18 August 2016

APHS/PPS Review of EPA Acoustics Comments for SSD Submission

In this letter, we provide responses to acoustics-related concerns raised by the NSW Environmental Protection Authority (EPA) in relation to the SSD submission for the Arthur Phillip High School (APHS) and Parramatta Public School redevelopments.

Figure 29: Sensitive Receiver/Noise Monitoring Locations (source: Applicant)

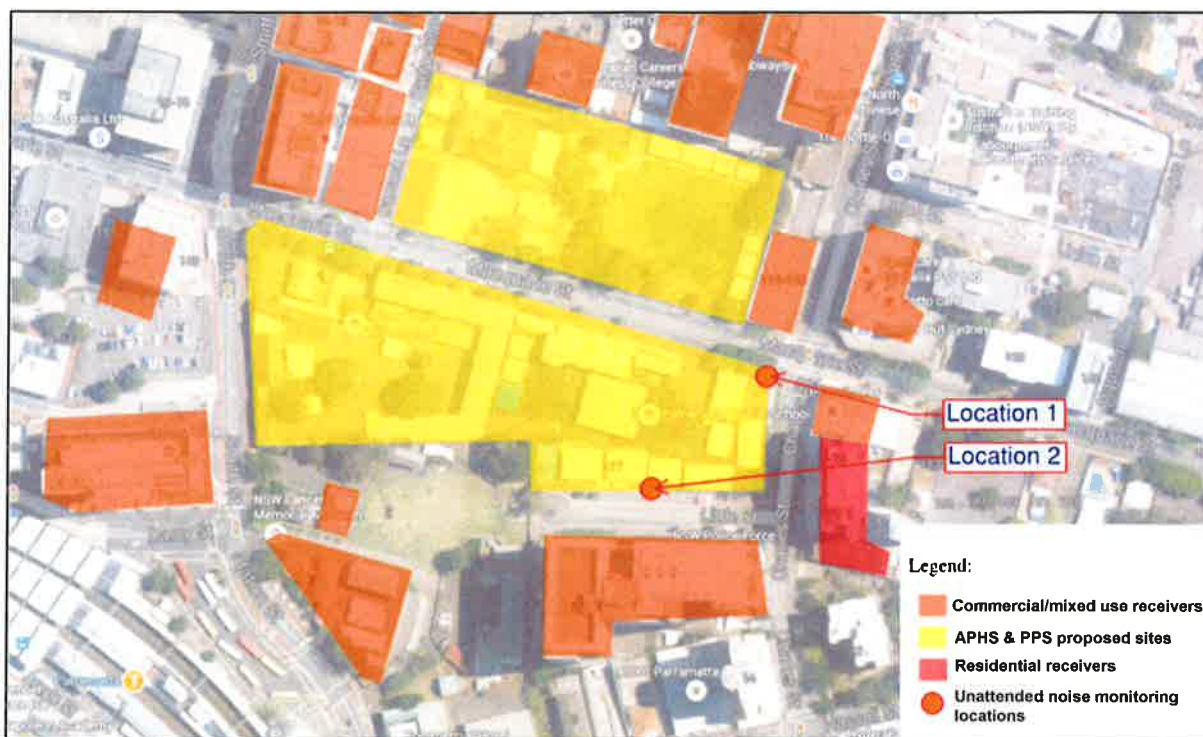
- *Background noise monitoring was undertaken at 2 locations rather than the most affected noise sensitive receivers;*
- *Background noise monitoring was undertaken during the first term of school rather than during school holidays;*
- *Daily graphs of noise logger measurements were not included; and*
- *Monitoring was likely to have been undertaken at street level whereas the most affected residences are located above street level,*

1. The background noise monitoring locations were selected to be representative of noise levels at receivers less exposed to road traffic noise (Location 2), and at receivers more exposed to road traffic noise (Location 1). Based on this, we do not consider it necessary to undertake additional noise logging.

4. We generally try to avoid noise logging at residences, as we cannot be sure of the contribution from occupied noise at the residence itself. As a 'worst case' assumption, we can update the noise egress limits at the residential receiver to be based on the measurements at Location 2, considering the receiver is further away from Macquarie St than Location 1.
